UPDATE TO OXFORDSHIRE COUNTY COUNCIL'S RESPONSE TO CONSULTATION ON THE FOLLOWING DEVELOPMENT PROPOSAL

Application No: 17/02534/OUT-3

Proposal: OUTLINE - The construction of a business park of up to 60,000 sq.m (GEA) of flexible Class B1(a) office / Class B1(b) research & development floorspace; parking for up to 2,000 cars; and associated highways, infrastructure and earthworks

Location: Land North Of Bicester Avenue, Garden Centre, Oxford Road, Bicester.

# Basic Results Summary

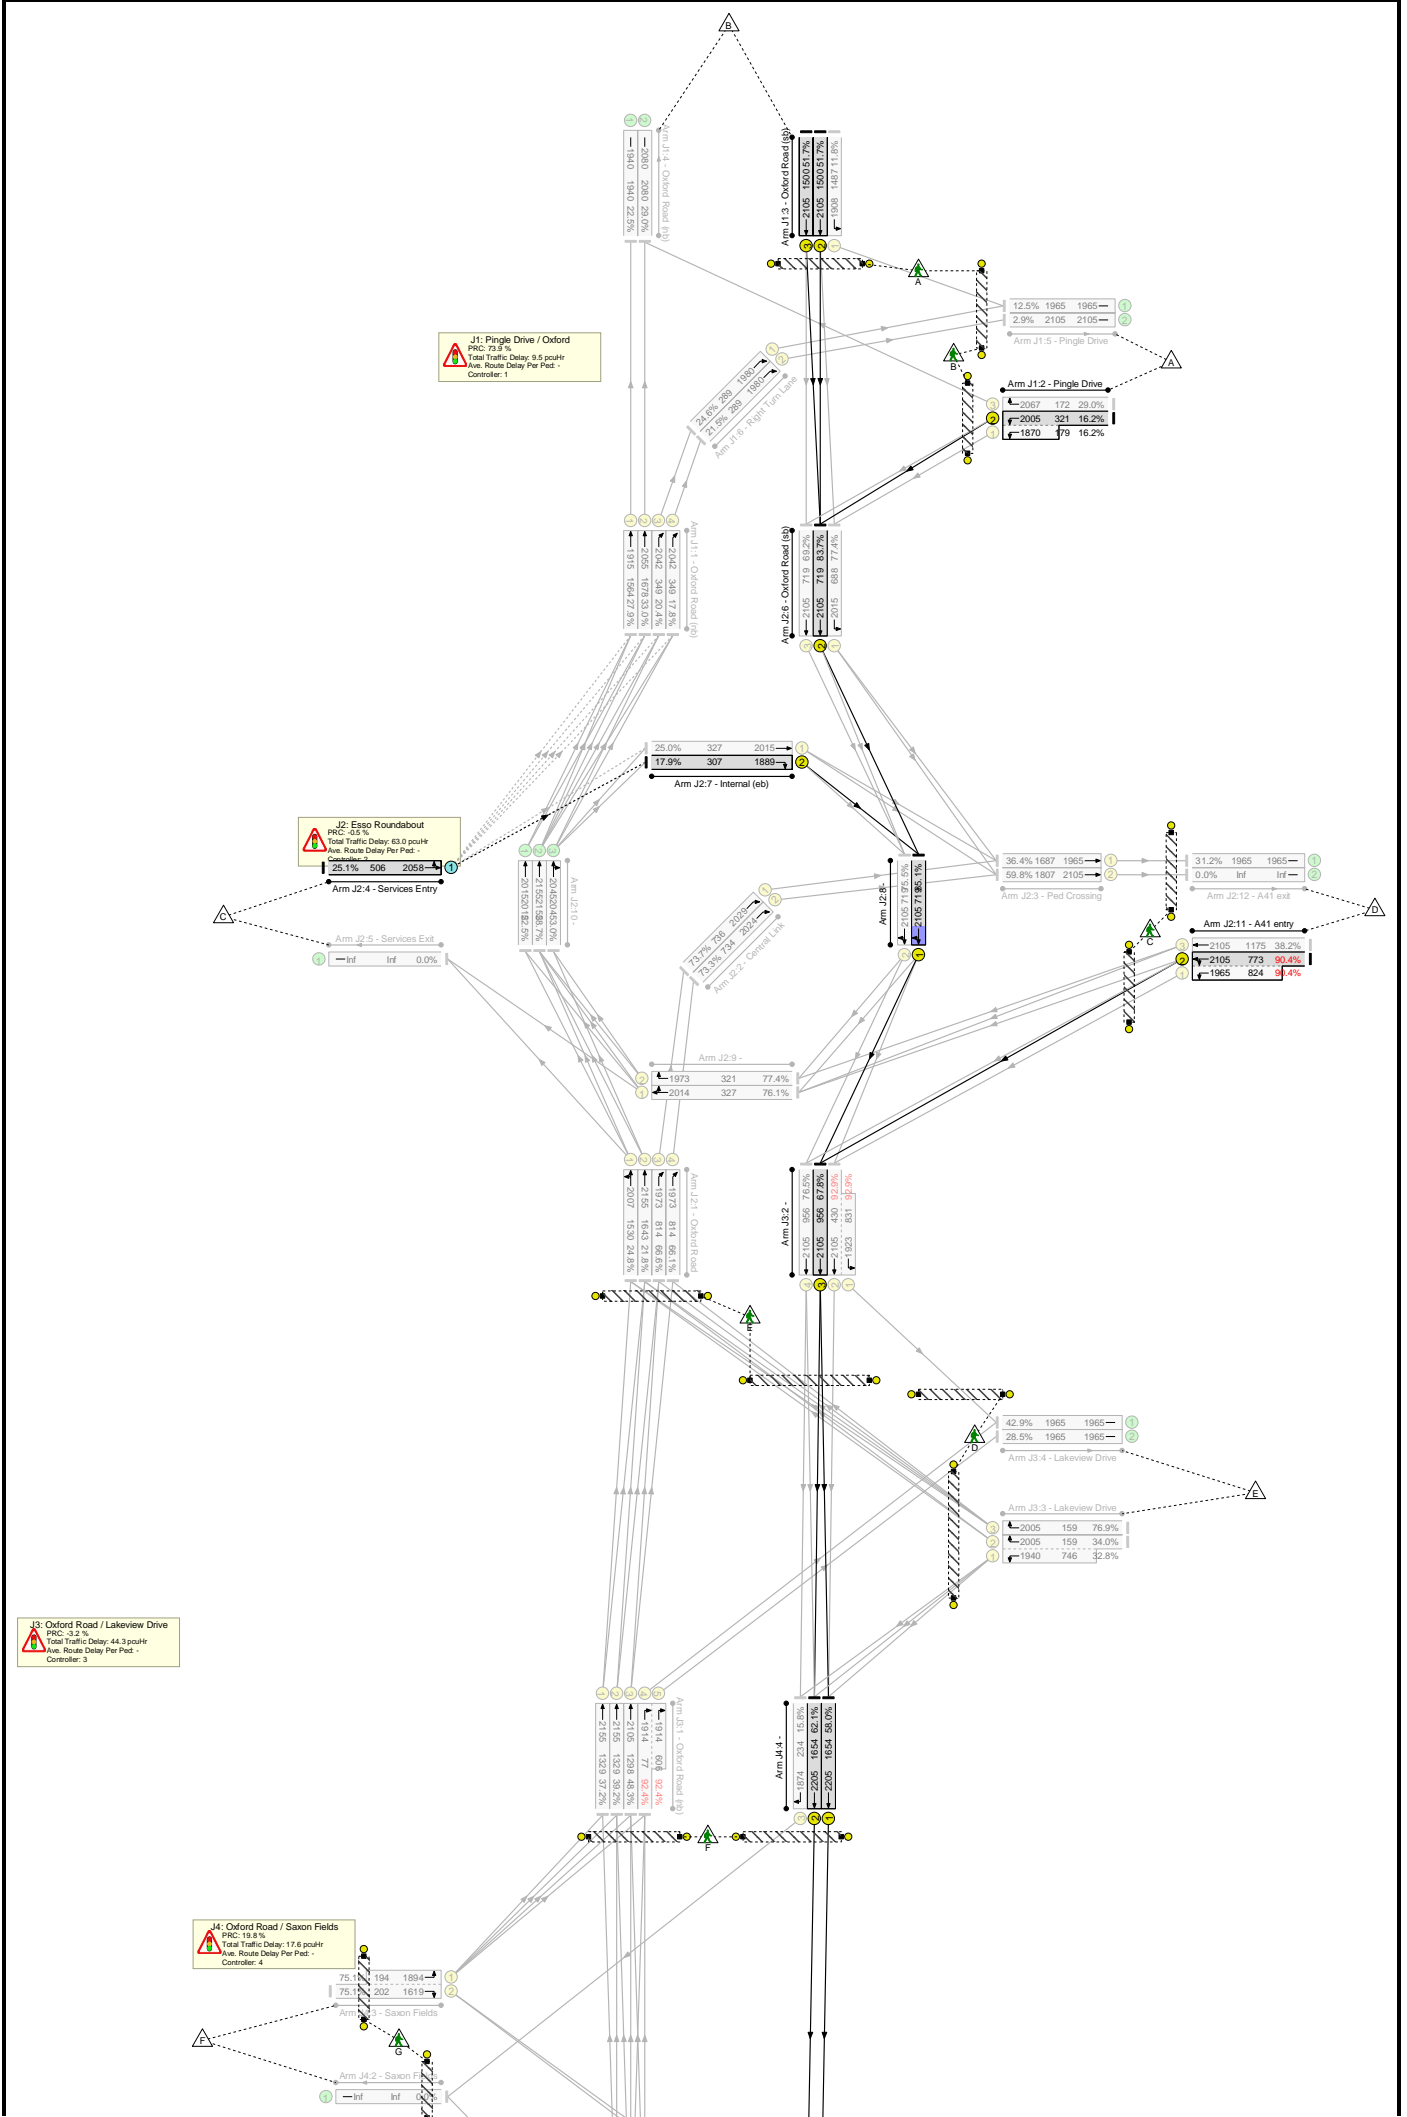
- The services entry arm (from the Esso filling station and Burger King) on the Esso Junction is a give way lane represented as J2:4/1. This arm has been incorrectly configured as having no opposing lanes – which gives an unrealistically high capacity for this approach

- Matrix estimation indicates that not all turning counts have been entered. Looking at the PM demand flow for the same approach arm (services entry arm of Esso Roundabout), only 98 pcu's were modelled instead of 127pcu's. It is thought that if matrix estimation is being used, this should be completed.

- Lane widths used in the model are incorrect. Where it has been possible to measure lane widths from scale plans, the lane widths used in the calculation of saturation flow appear to be consistently wider than the measured lane widths. This probably won't make much difference to the results (the relative increase in capacity should be the same), as it is incorrect in both the base and proposed models. This however will result in an over optimistic calculation of saturation flows in both models.

- Saturation flows have shown to be generally higher than would normally be. This causes traffic capacity to be over-estimated. Where there is only one lane serving any given destination, the lane should be treated as a nearside lane in the saturation flow calculations. This is because slow vehicles will delay the entire route flow, unlike multiple lane / route choice approaches, where faster vehicles are able to overtake in the offside lane.

- The Oxford Road northbound stream (exit arm) of Pingle Drive/Oxford Road junction (presented as Arm J1:4 in the model) is shown without a pedestrian crossing across it, despite a signalled crossing across southbound. Presently, a pedestrian crossing goes across both the northbound and southbound traffic streams. This modelling inaccuracy is likely to create an artificially higher saturation across the junction.

- Use of lane connectors to allow weaving will allow overly optimistic distribution of traffic flows and allows inappropriate route selection. If/where lanes are not immediately available at the exit of the previous junction, intermediate exit lane lanes may be required to accurately model lane and route choices. Alternatively, route flows may need to be manually set to manage traffic flows on weaving connectors.
